Please see comments from Private Sector Housing below.

Application No: BR/110/20/PD

Site Address: 8 Longford Road Bognor Regis PO21 1AQ

Description of Works: Notification for Prior Approval under Schedule 2, Part 3, Class M for the change of use from a shop (A1 shops) to 1 No dwelling (C3 Dwelling house).

Proposed Ground Floor Plan
Scale: 1:50

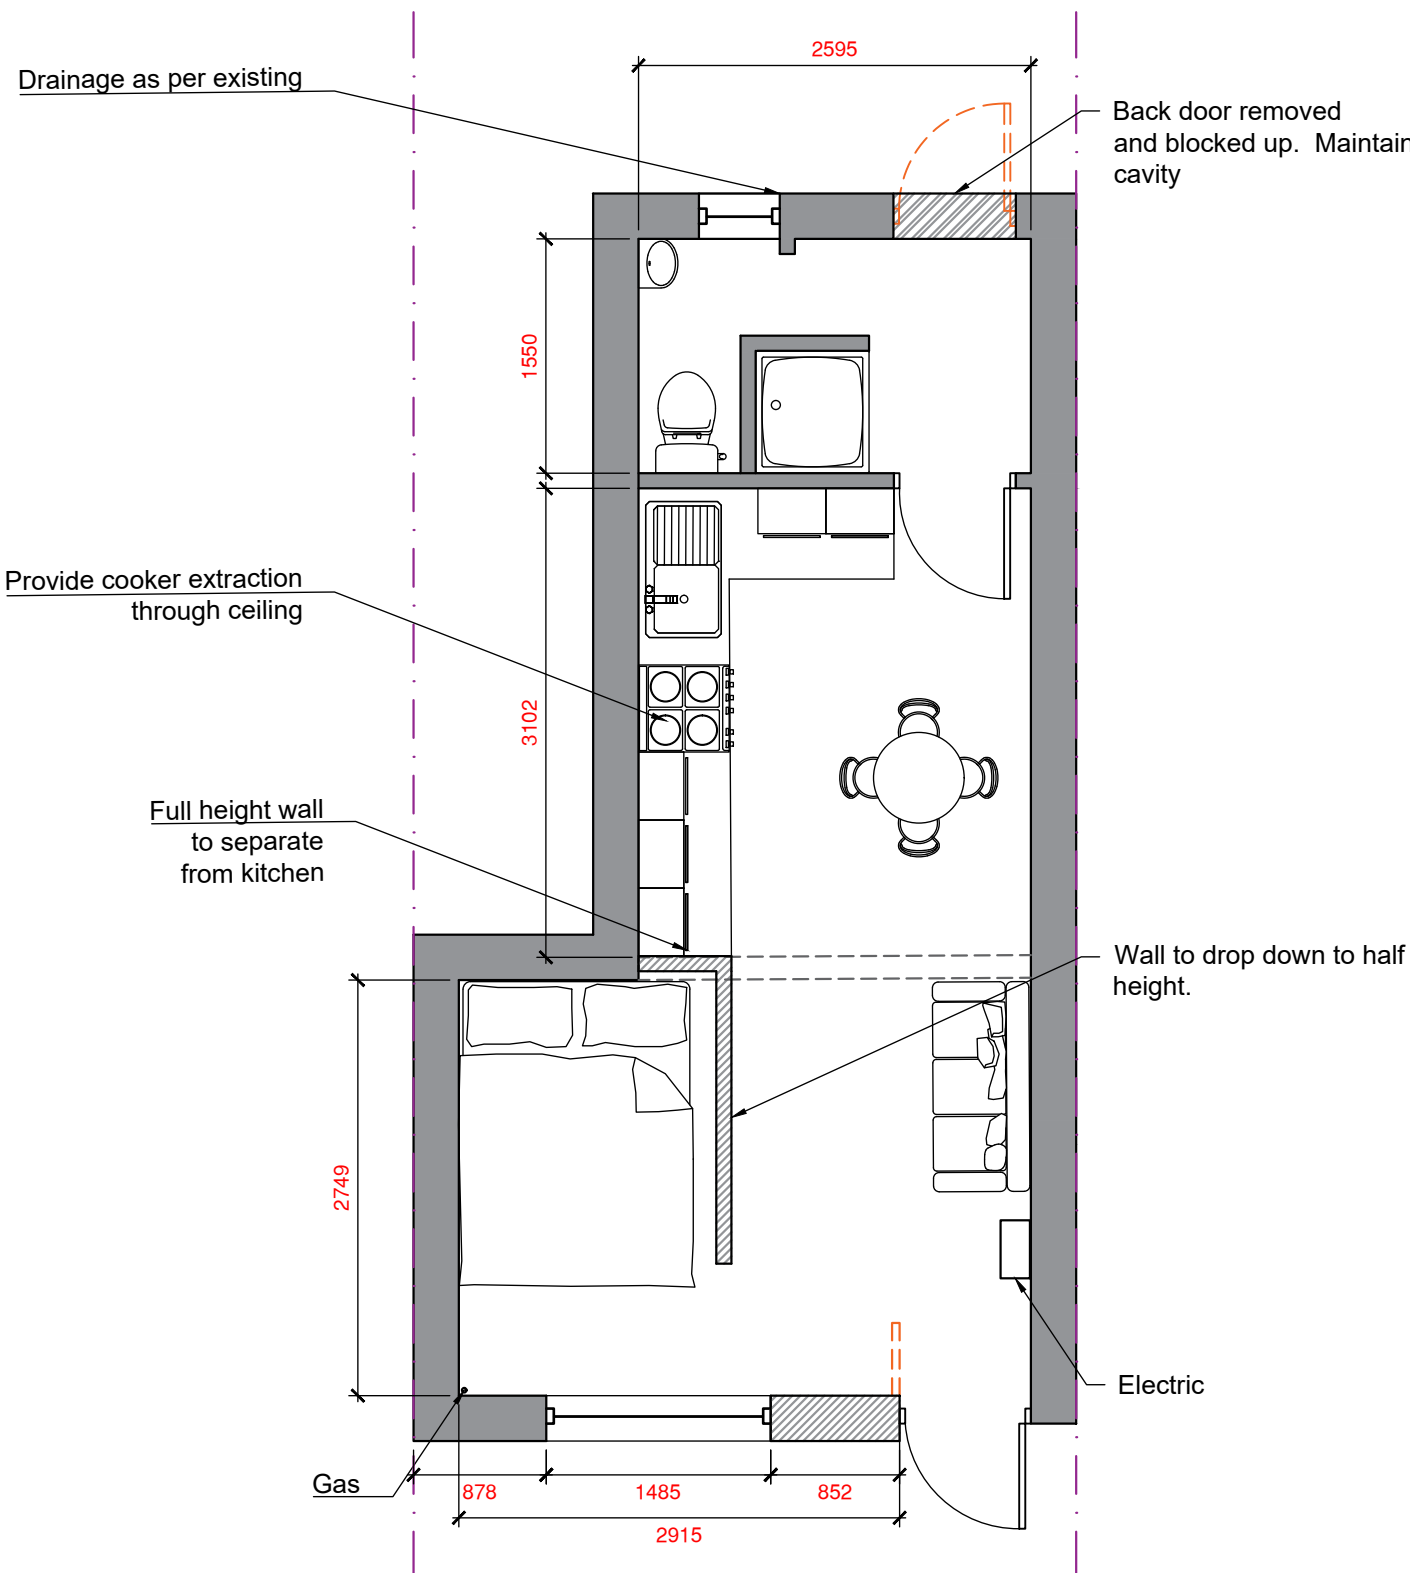
- Consideration should be given to re-locating either the cooker or sink and drainer unit as there is the potential for the occupier to burn or scald themselves on the cooker whilst using the sink
